**From:** [REDACTED]  
**To:** [Norfolk Boreas](#)  
**Subject:** Written submission of Open Floor hearing statement by Julian Pearson  
**Date:** 18 November 2019 18:57:27  
**Attachments:** [Boreas-Statement Arquements and images for open Floor hearing.docx](#)

## POINTS OF ARGUMENT AGAINST THE APPLICATION FOR BOREAS.

My comments are based around the substation at Necton and the applicants document "Chapter 29 'landscape and visual Impact assessment'"

Title:	Scenario 1 Viewpoint 4: A47 Necton Substation
--------	---

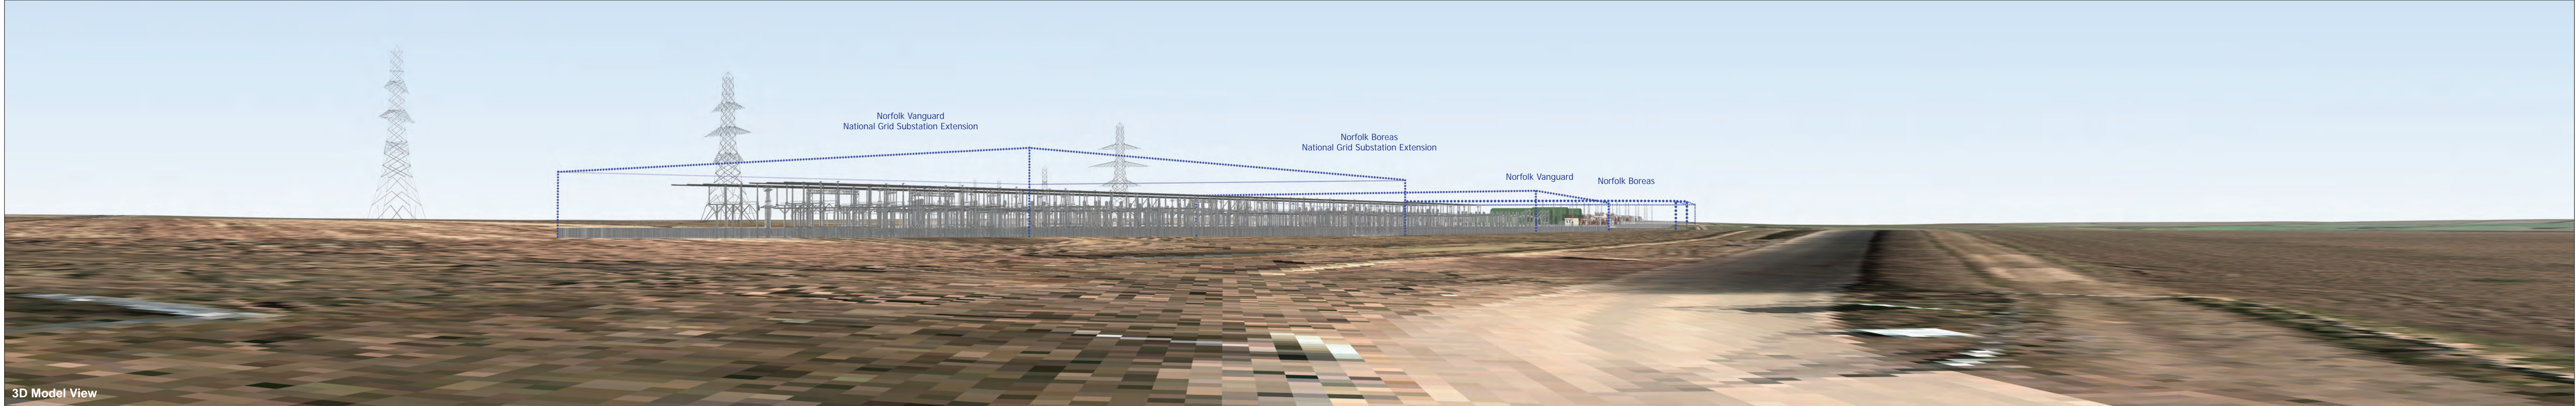
At near ground level, yes, I agree, but without details of the mitigation of the visual impact of the 19m tall buildings, each 110m wide, the planted landscape cannot be reasonably considered as adequate mitigation

Specified bunding is a paltry 1m and 2m high and only to the western side of the project, leaving the south west, south, and south east totally open, before the woodland shields the view from Bradenham (East).. there is reference elsewhere in Chapter 29 mentioning that there is minimal earthworks to create a level construction area.. and with the lack of earth, comes a lack of bund height and length.

Paragraph 137 clearly states that after 20 years, even the 'Nurse' species of planting would only be 7m growth above ground level .'. 8m or 9m when on a bund.. compared to the 19m of the building

height and after 30 years, they would be just 9.5m in height... the Core species, would be considerably shorter.
